From: Andrew Wood <Andrew.Wood@arun.gov.uk>
Sent: 05 January 2021 07:16
To: Planning.Responses <Planning.Responses@arun.gov.uk>
Subject: FW: Objection to 70a Tarrant St Planning Application Ref: AB/118/20/PL

Planning Application Ref: AB/118/20/PL

70a Tarrant street.

Re. The planning Application to develop the existing garage into a 3 storey building with 2 self contained flats.

West Sectional Elevation - Proposed

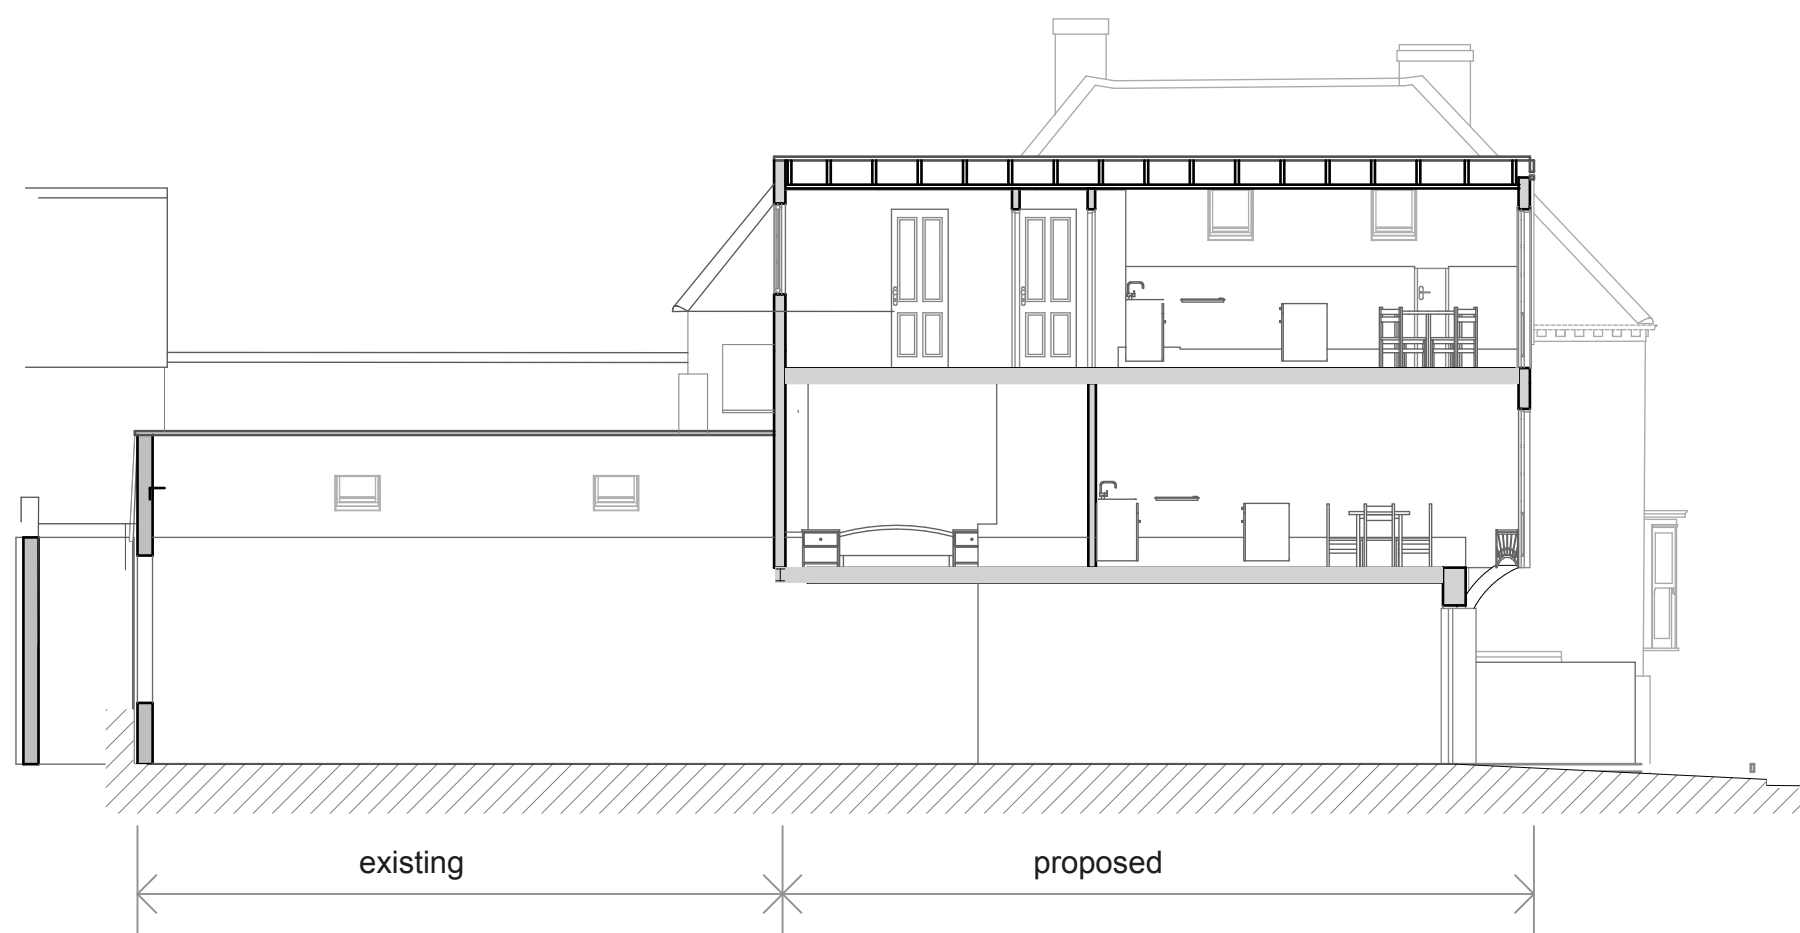
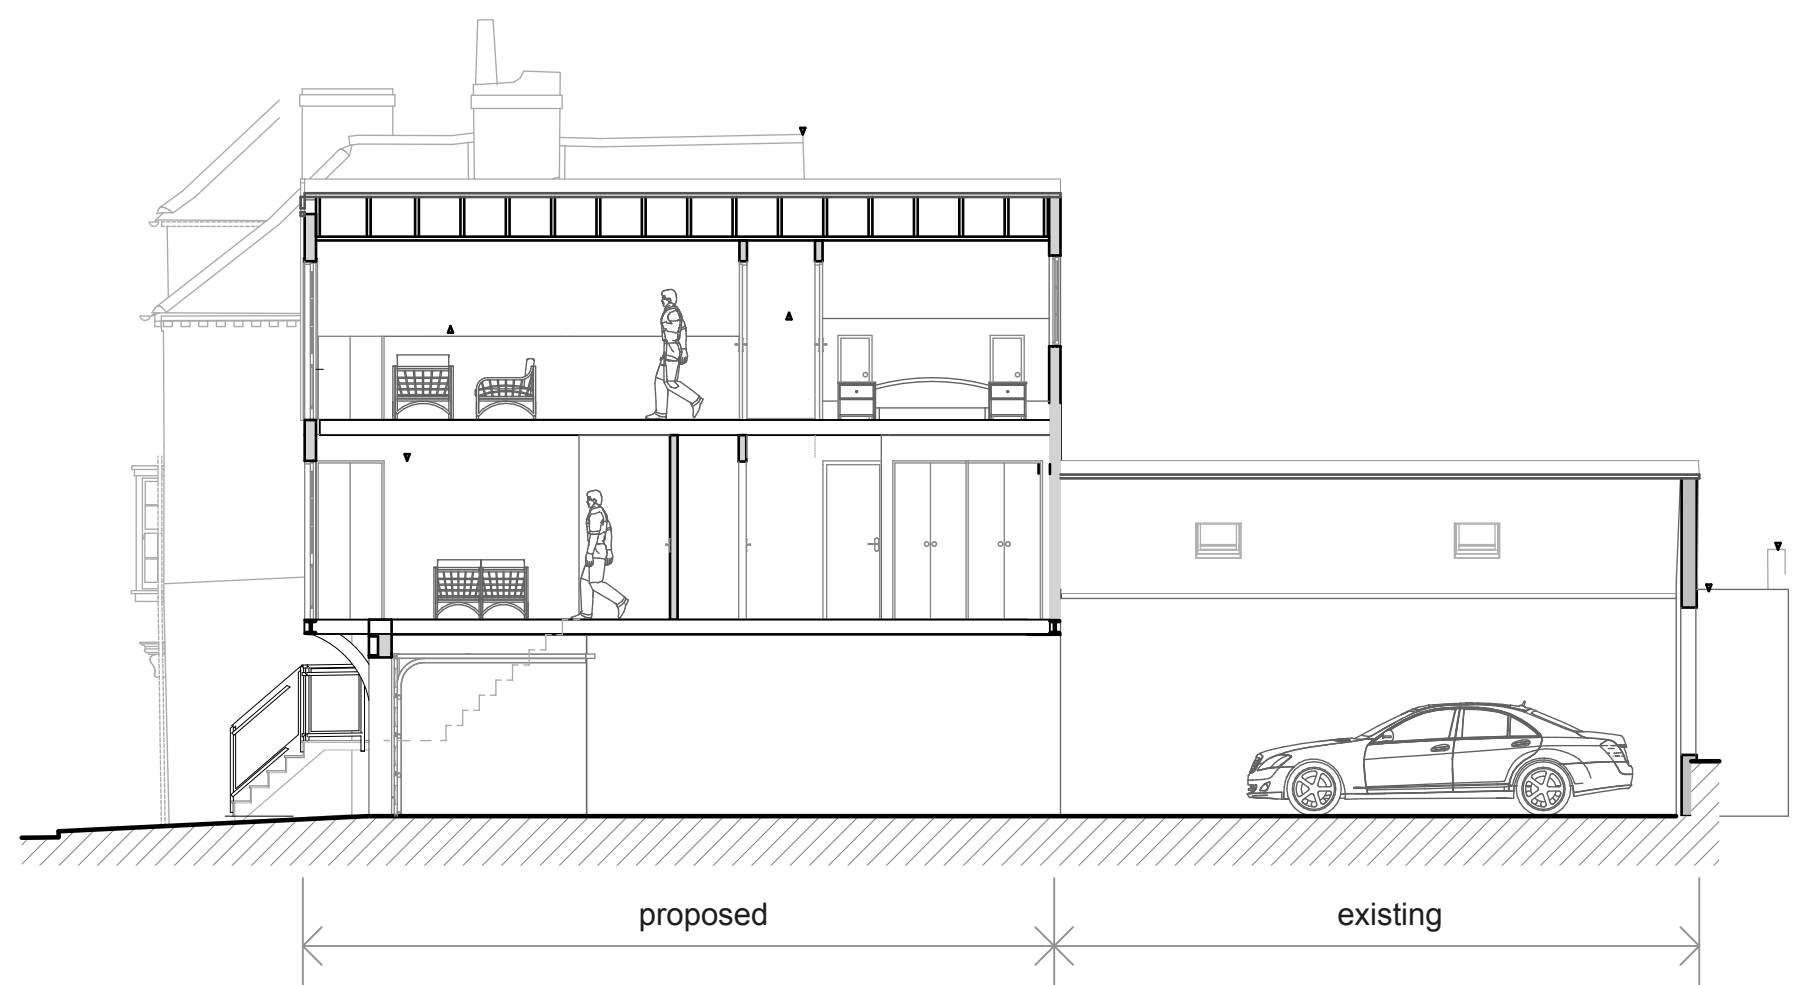
On reviewing the plans in more detail there appears to be some discrepancy between the side elevation sections and the front elevation sections where the height of the property compared with adjacent properties appears to differ. The total height of the planned property controls how large it is overall and how it sits relative to adjacent properties. Perhaps there is some perspective involved in the plans but it is not clear to us in this case where the perspective point sits, and if so whether it would then also apply to the front elevation section, which if it did would imply the house could be higher than adjacent ones as it is set back from the road.

West and East section elevations suggest roof height of new build lower than adjacent properties, but front elevation view shows property height same or similar not lower?

North Elevation - Proposed

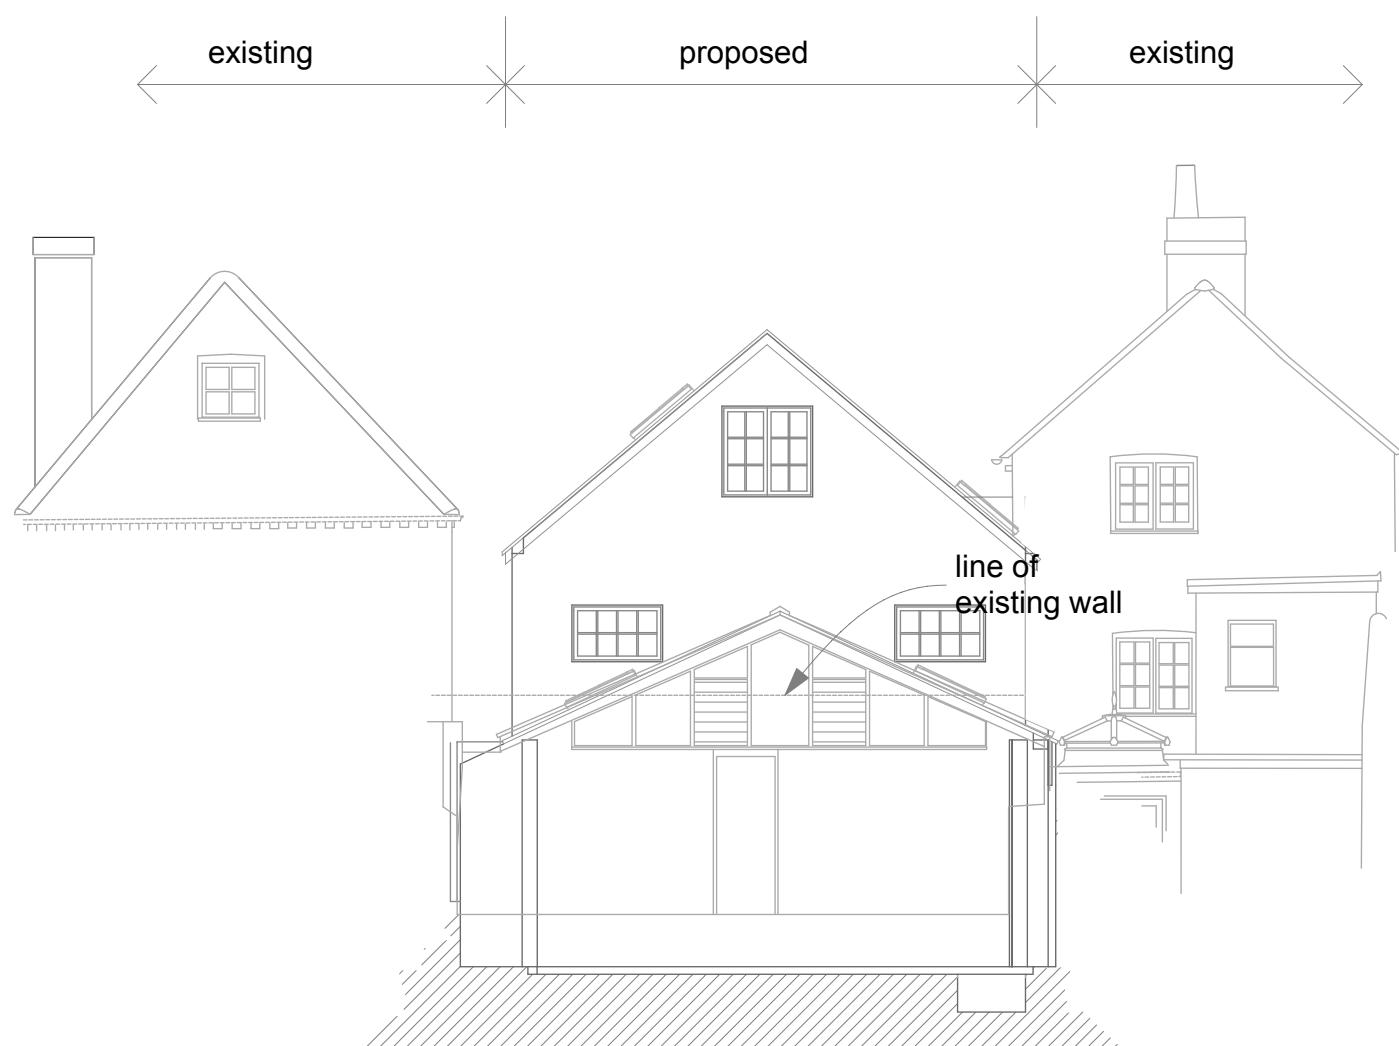
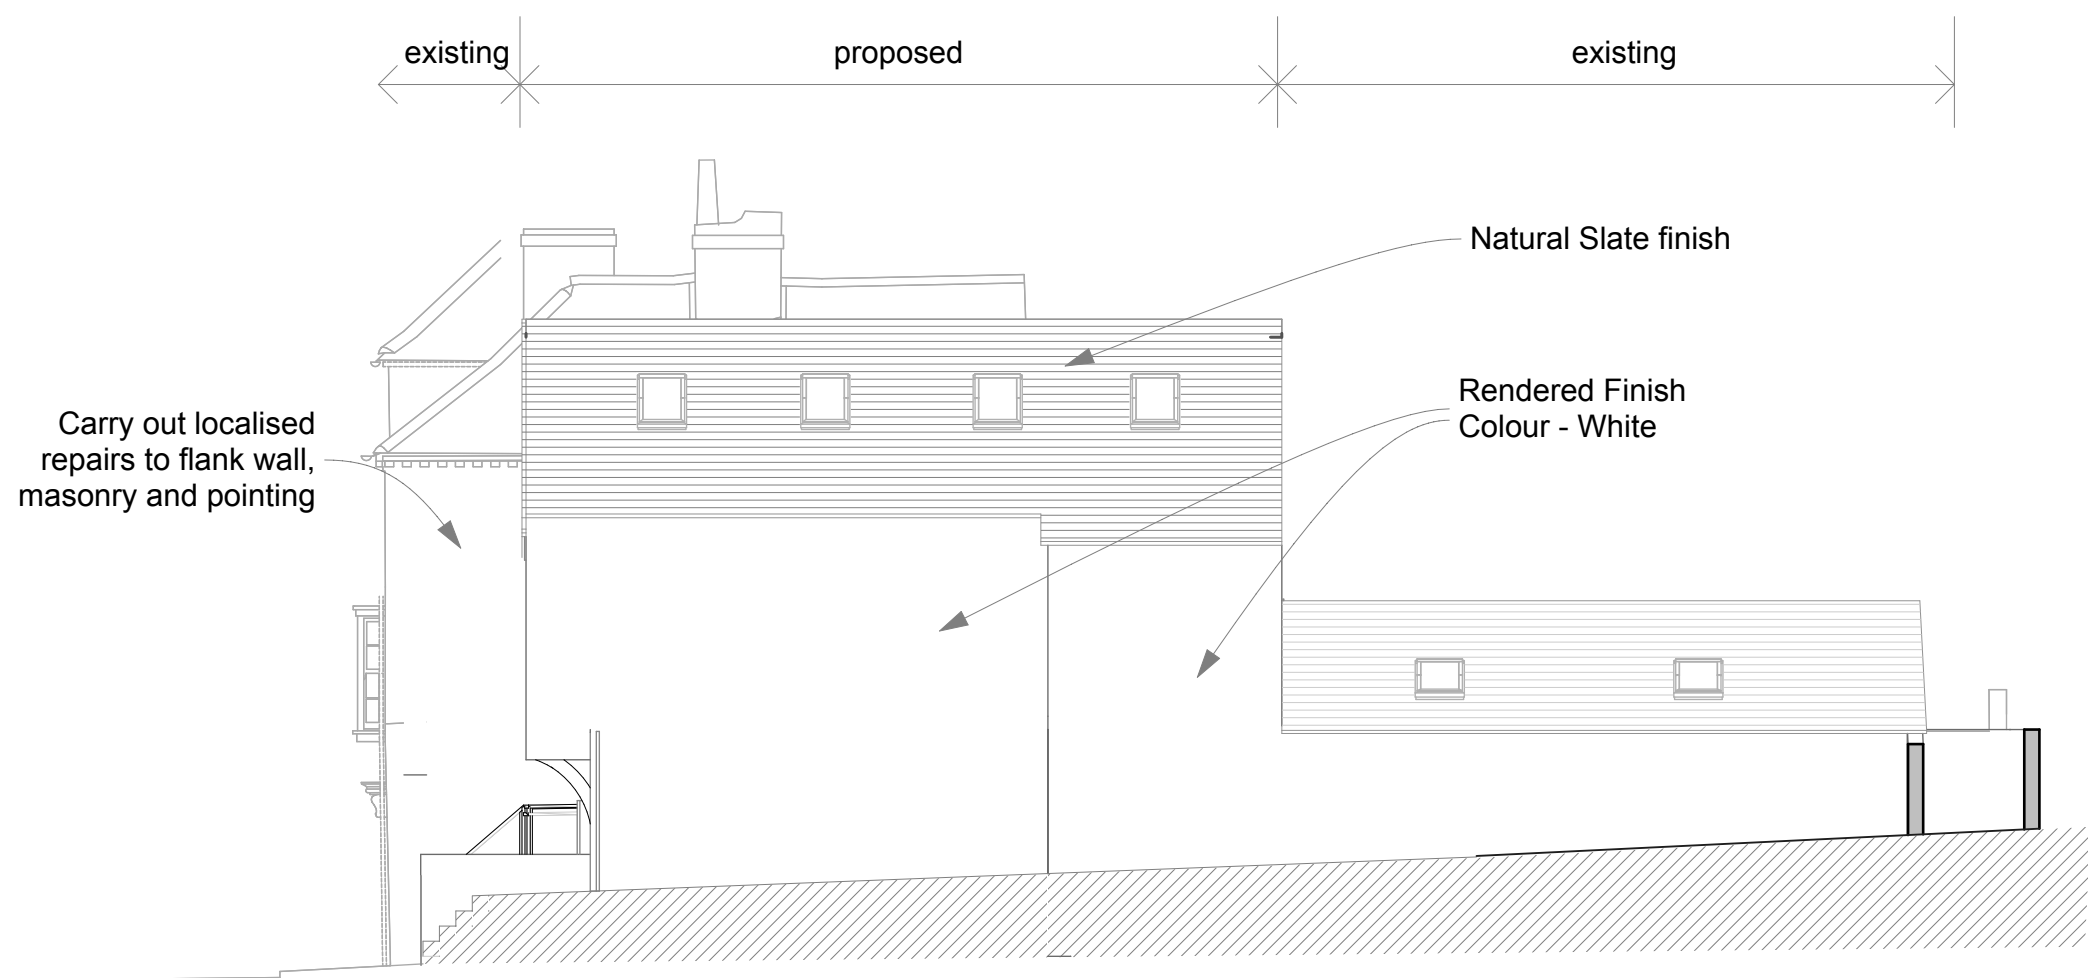
We are concerned that the proposal of employing glass doors and Juliette balconies at the front of the building will result in noise disturbance particularly as these will likely front living rooms at both levels. The close proximity of terraces of buildings and the narrowness of Tarrant Street at this point mean that acoustics are channelled and amplified. In milder weather and throughout the summer these doors would inevitably be open and sounds/noise that would normally be restricted to the household (music, tv, loud conversation), will be regularly emanating from the 2 proposed flats directly towards the bedrooms on the first and second stories of the opposite properties causing a nuisance and disturbance.
